# CITY OF ALBUQUERQUE

**Re: RXI Innovation  
7209 Jefferson St NE  
Traffic Circulation Layout  
Architect's Stamp 08-31-2020 (D17-D041)**

Based upon the information provided in your submittal received 09-01-2020, the above referenced plan cannot be approved for Building Permit until the following comments are addressed:

2 MOTORCYCLE PARKING SIGN

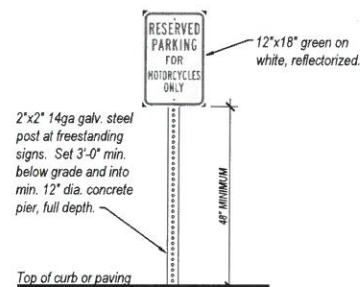
9. Motorcycle parking spaces shall be designated by its own conspicuously posted upright sign, either free-standing or wall mounted per the zoning code. Label pavement MC (Provide sign face detail of sign and post).

SHEET TITLE:
TCL SITE PLAN

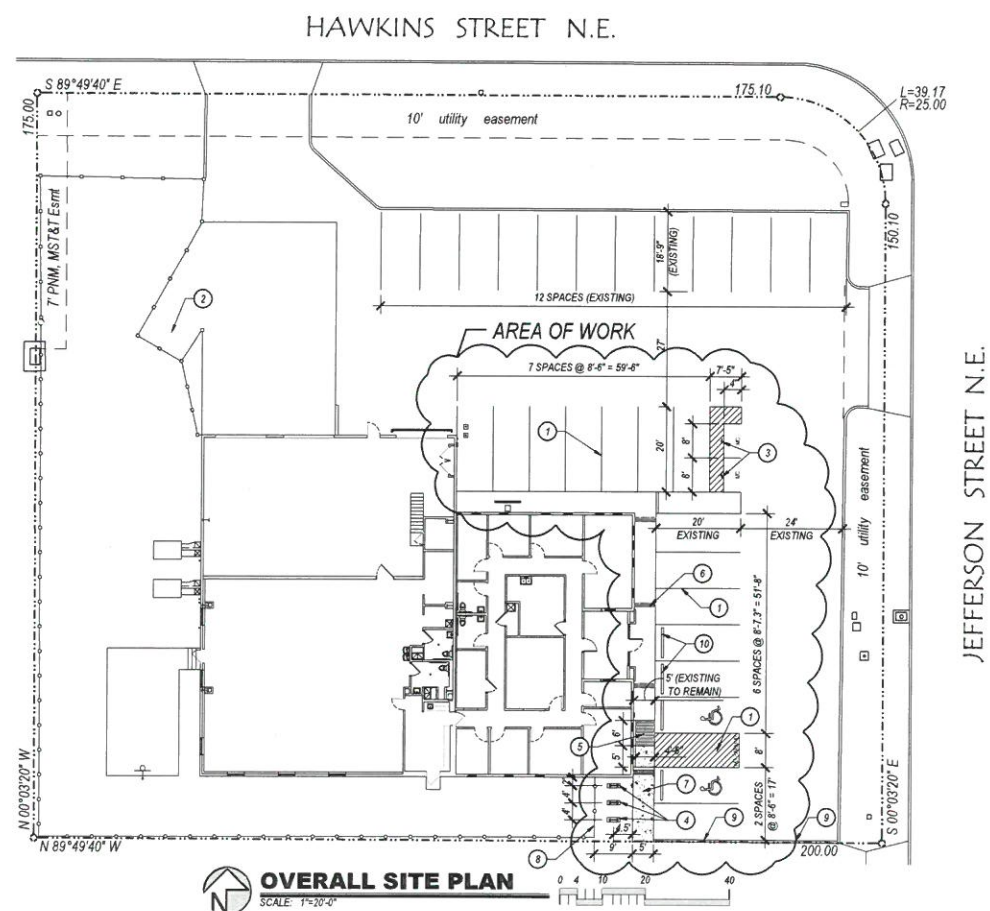
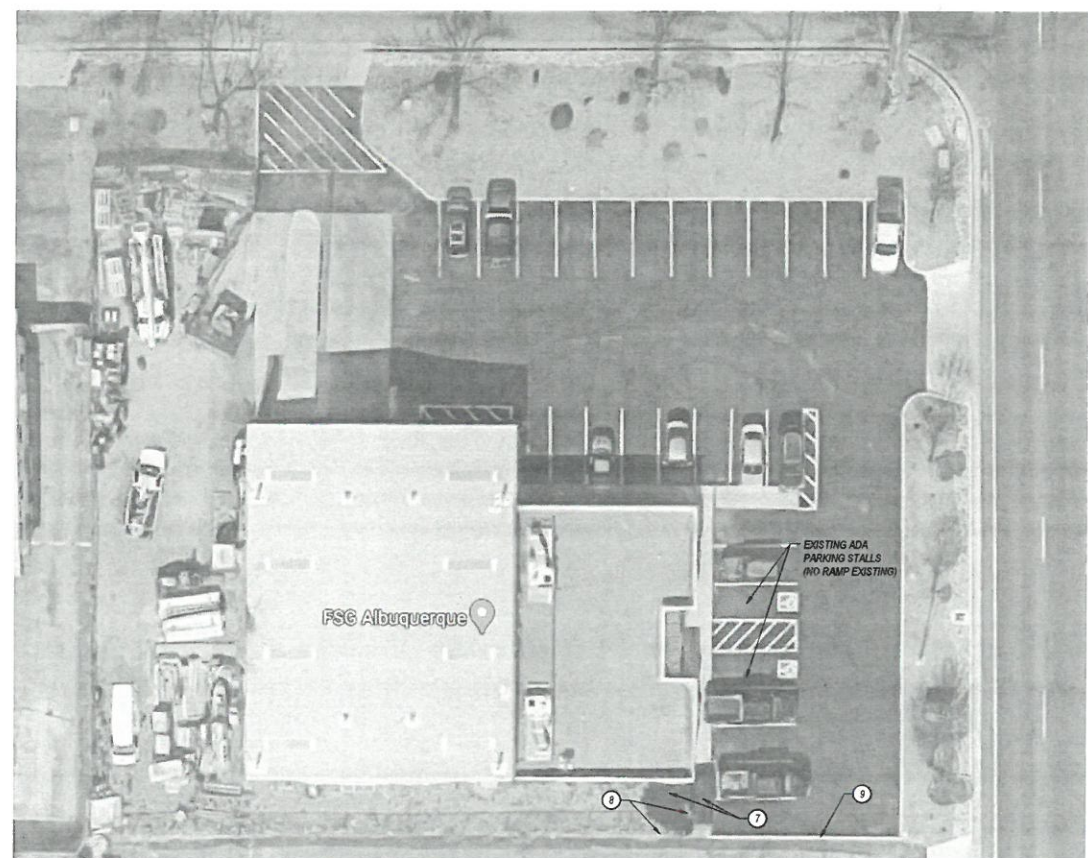
1. List the number of parking spaces required by the zoning code as well as the proposed number of parking spaces including *bicycle* and motorcycle parking. All proposed required calculations need to be discussed with Zoning.
2. Clarify the extents of the current phase. Provide a phasing plan (Not just a bubble).
3. Identify all existing access easements and rights of way width dimensions.
4. Identify the right of way width, medians, curb cuts, and street widths on Hawkins Street and Jefferson Street.
5. Maximum access width for **arterial** (Jefferson St), collector, and **local streets** (Hawkins) are as follows:

6. Please list the **widths** and length for all existing and proposed parking spaces. Some dimensions are not shown.
7. The minimum parking stall dimensions are:

10. All bicycle racks shall be designed according to the following guidelines:
  - a. The rack shall be a minimum 30 inches tall and 18 inches wide.
  - b. The bicycle frame shall be supported horizontally at two or more places. Comb/toaster racks are not allowed.

14. A 5 ft. keyway is required for dead-end parking aisles.
15. Per the IDO, a 6 ft. wide ADA accessible pedestrian pathway is required from the public sidewalk to the building entrances. Please clearly show this pathway and provide details.

17. All sidewalks along streets: There should sidewalk on both frontages (Hawkins and Jefferson). Provide widths along both segment of the streets.
18. Parking areas shall have **barriers to prevent vehicles from extending** over public sidewalk, public right-of-way, **ADA 6ft pathway fronting building** or abutting lots.
